TEXT_AQUIND_ISH1_Session5_09122020

question 4.3 on the agenda in light of the section 35 direction from the Secretary of State, could Portsmouth city council and indeed any other local authority that considers that the commercial you use spare capacity within the fibre optic cables, and the associated input infrastructure cannot be covered and Authorized by the powers of in the draft development consent order. Please explain why they believe this to be the case. What would prevent the surplus capacity from being considered part of the proposed development

**TEMPORARY CAR PARK: UP TO 206 PARKING BAYS,
14 LGV PARKING BAYS & 7 HGV PARKING BAYS**

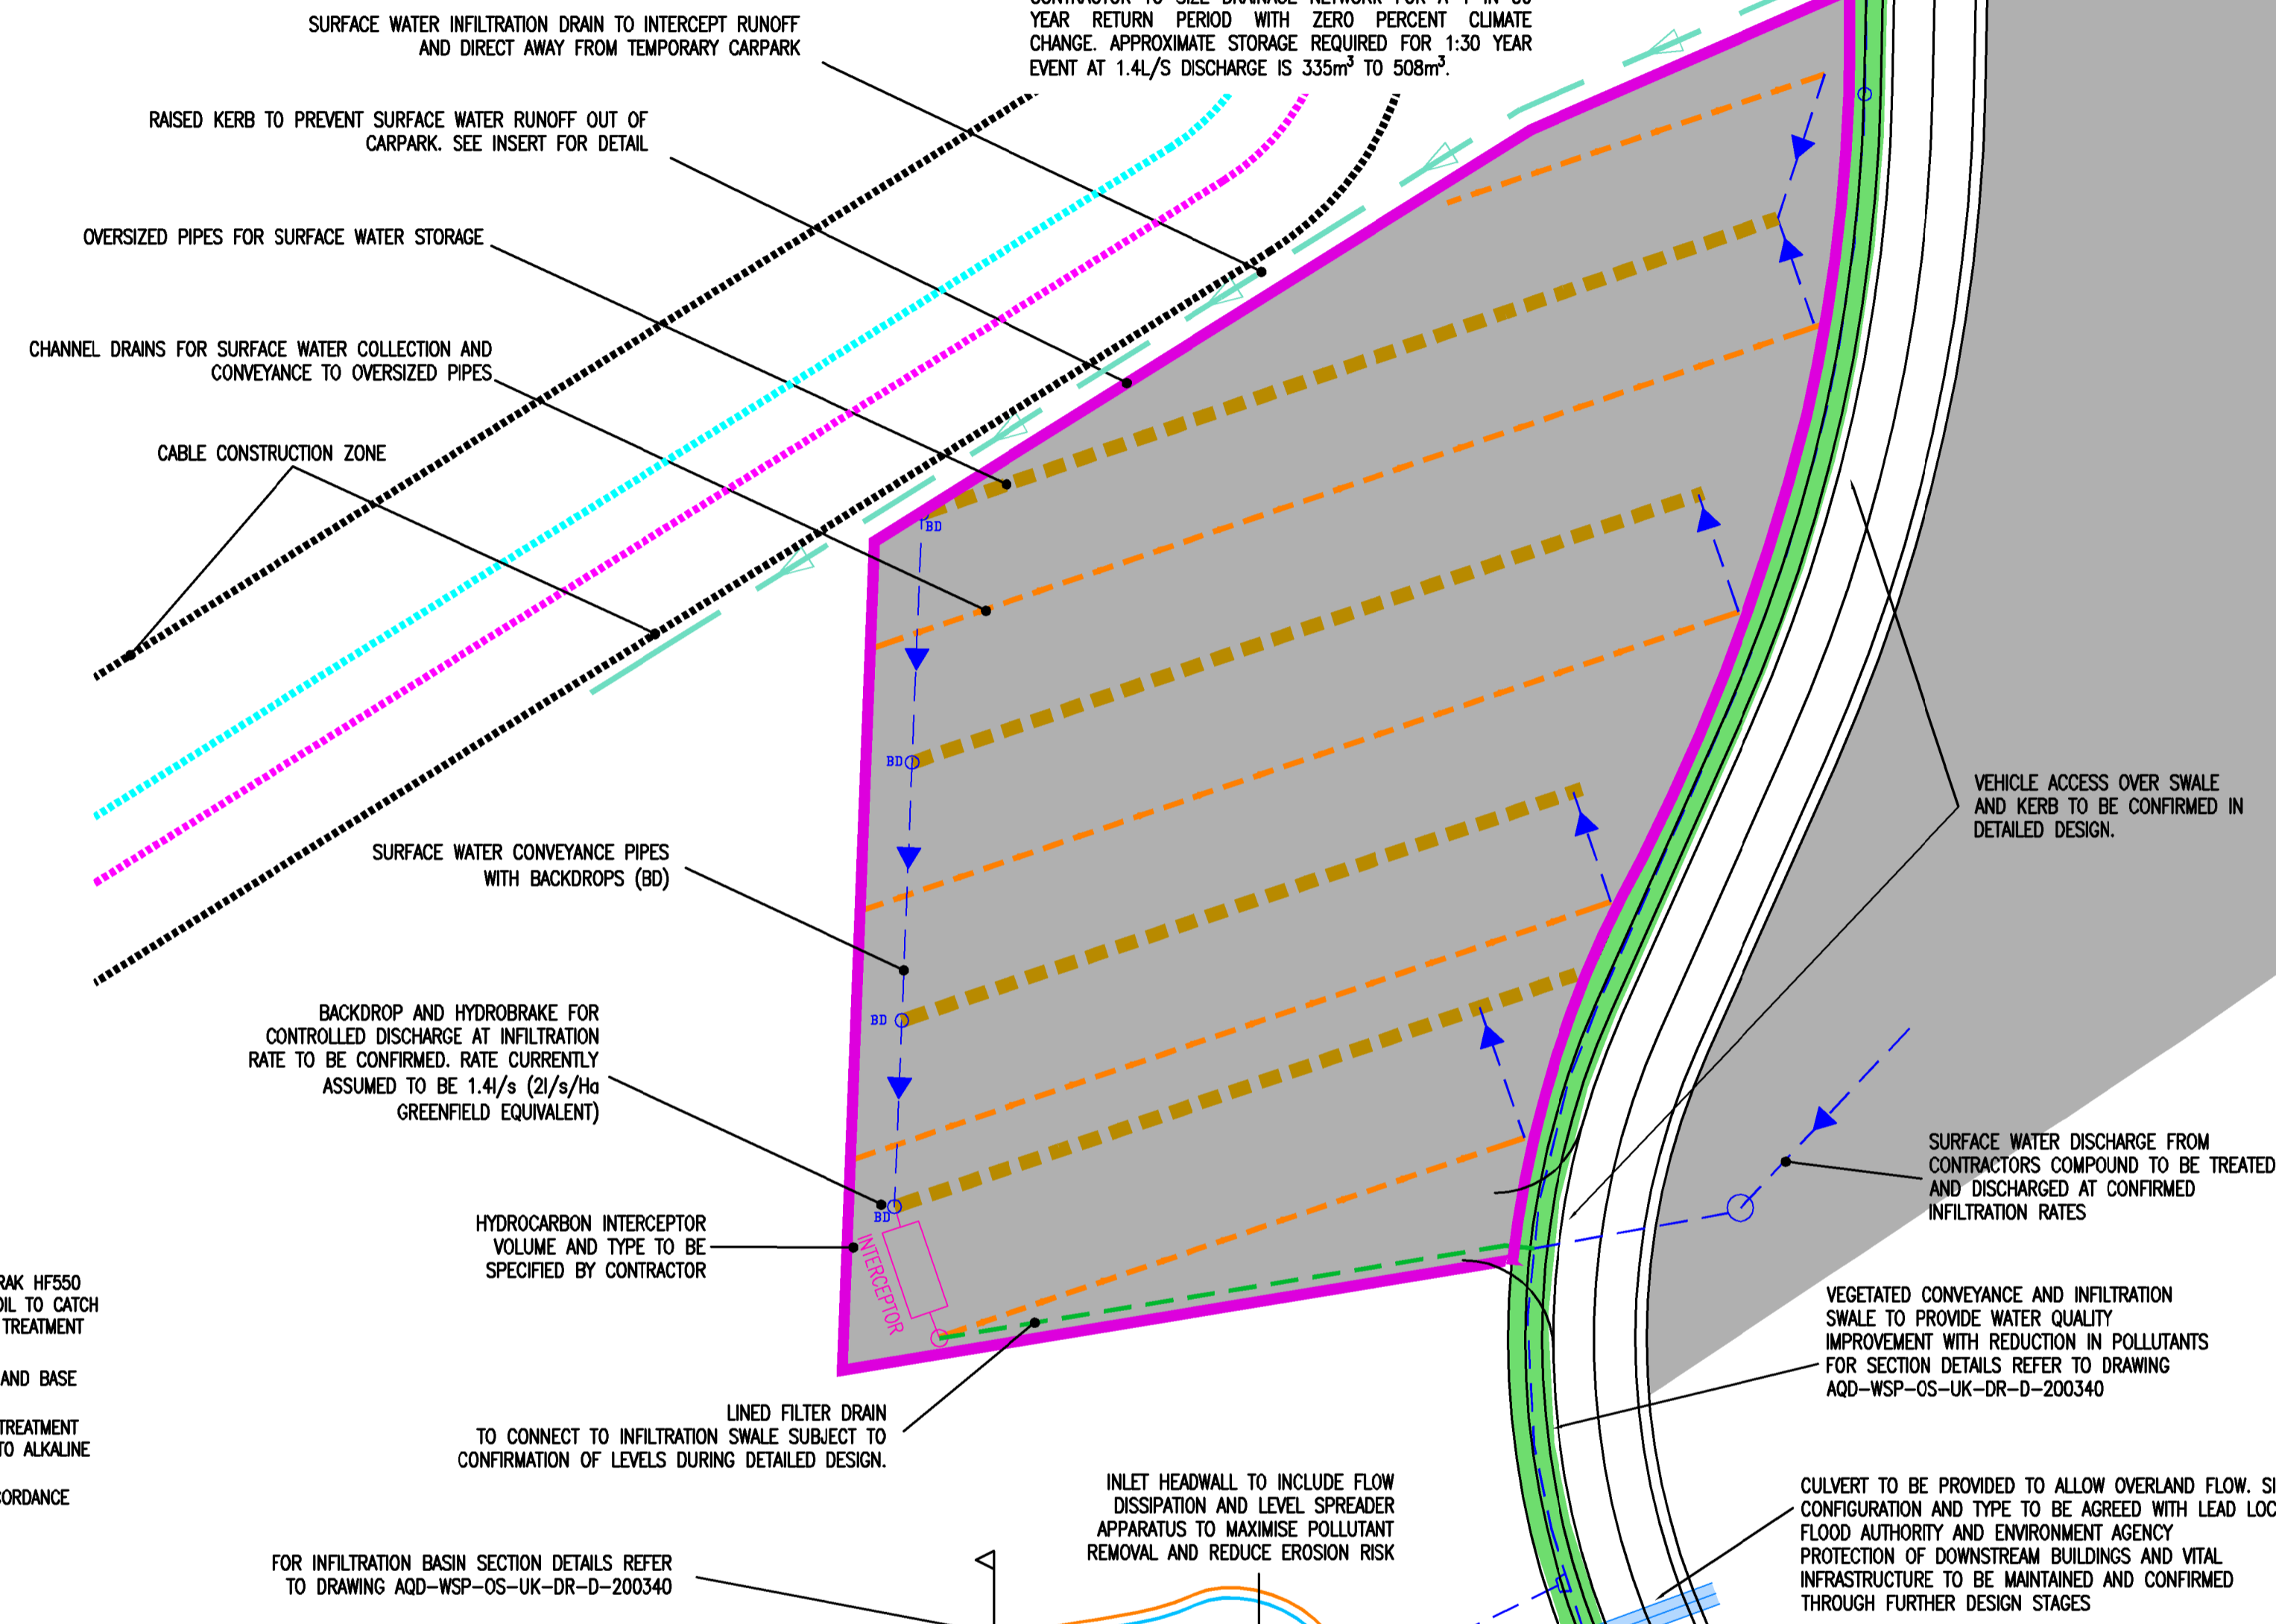
Question 4.5 on the agenda with regard to work number three, what is the actual size of the carpark sought? The supplementary transport assessment infers 150 space carparks, but the answer to x q one

point 16 point 20 states capacity for 227 parking spaces? Where are the parameters of this set? And how is the size and location controlled in the DCO? Mr. Jarvis?

Thank you, sir. So, the size of the car park is for 206 vehicles. There is a table included within my statement at question 4.5 and that sets out the car movements in connection with the authorized development and that includes the worker movements comprising the workers at the converter station area, the workers on the cable route and the landfill and all together that equals 206 spaces and that's what the carpark is sought for. The higher 227 figure that was included in the response at our response to SAS written questions takes into account the vehicles that will be used in connection with the construction. So essentially, the vehicles that are used to transport the cable gangs, from the converter station to their specified area of work, or on the site itself, we are not separately seeking consent for additional car parking spaces for those vehicles, as it's considered they can be accommodated on the site in the parking area that's already provided for because of the turnover of cars and vehicles that will happen in that area. But what we are seeking to do is to ensure that a car park is big enough to accommodate all workers. This is obviously not subject to but we're also looking at various matters in relation to the framework construction traffic management strategies to provide a more sustainable way for persons to go to and from the converter station. But that doesn't aren't at this time necessitate any reduction in the car parking figure. And we don't consider that it would be appropriate to do so.
